Site Plan Drawing.pdf Markup Summary

# SITE PLAN

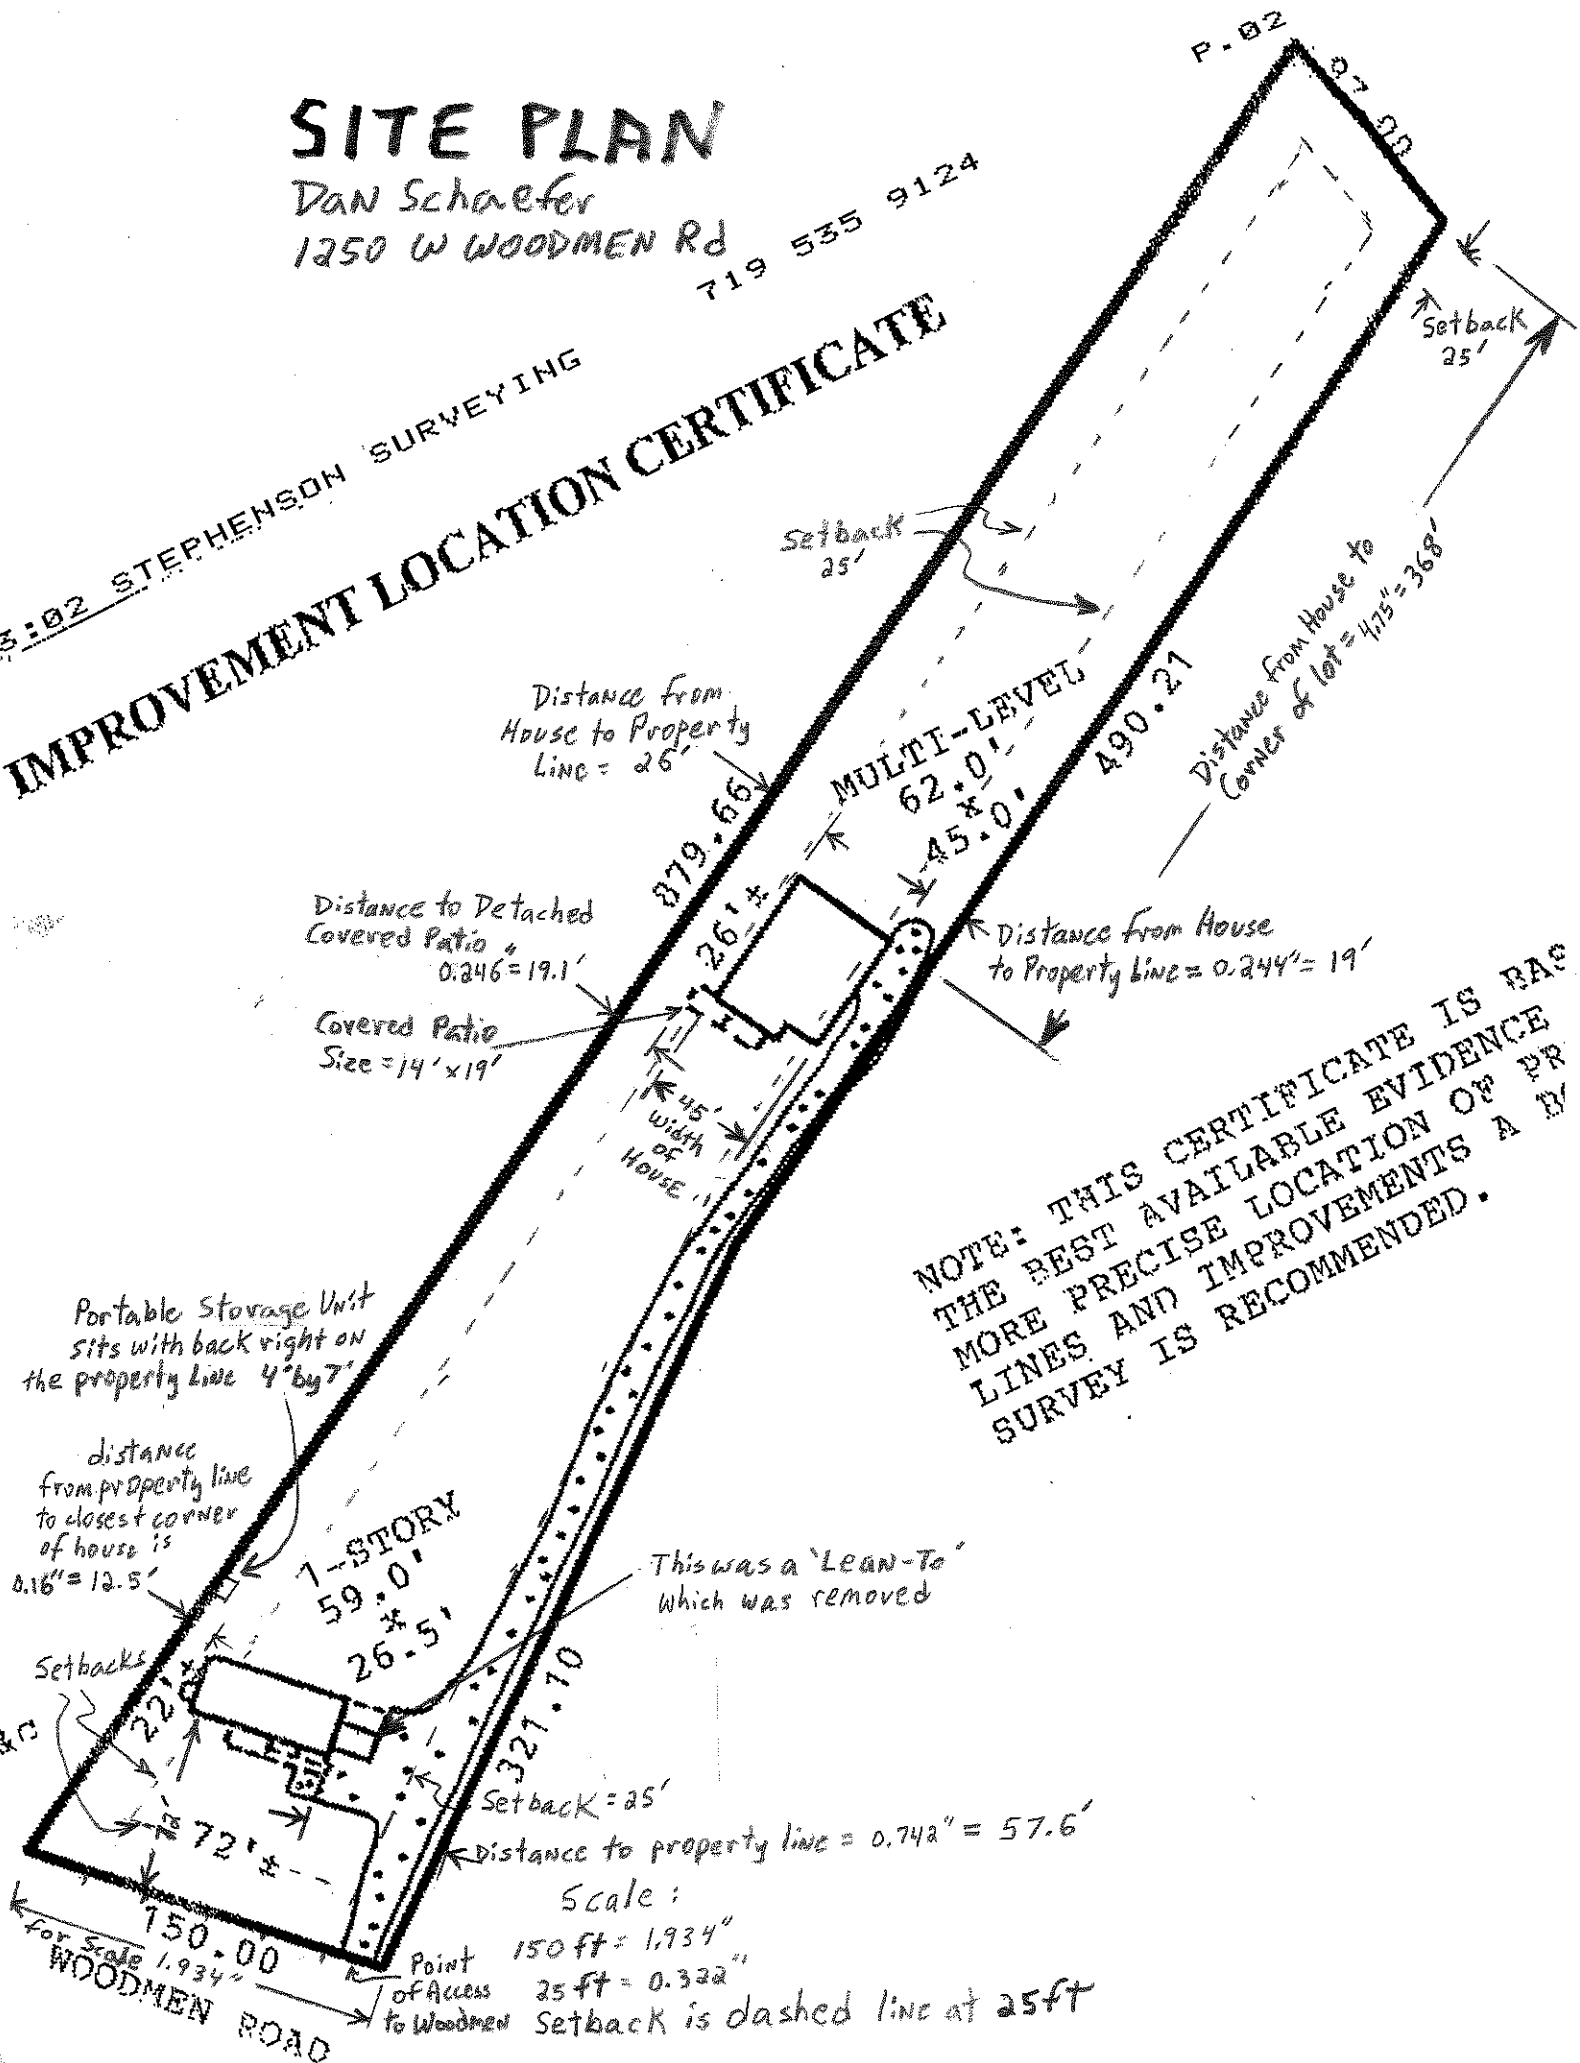
Setbacks as well

Need to know setbacks

setback to all property lines

Detached covered patio.

"to eat outside" not necessary on plan.

Setback is 25' all the way around the property lines.

Setback to property line

We need to know the exact property line and setbacks for all structures

We need to know the exact property line and setbacks for all structures
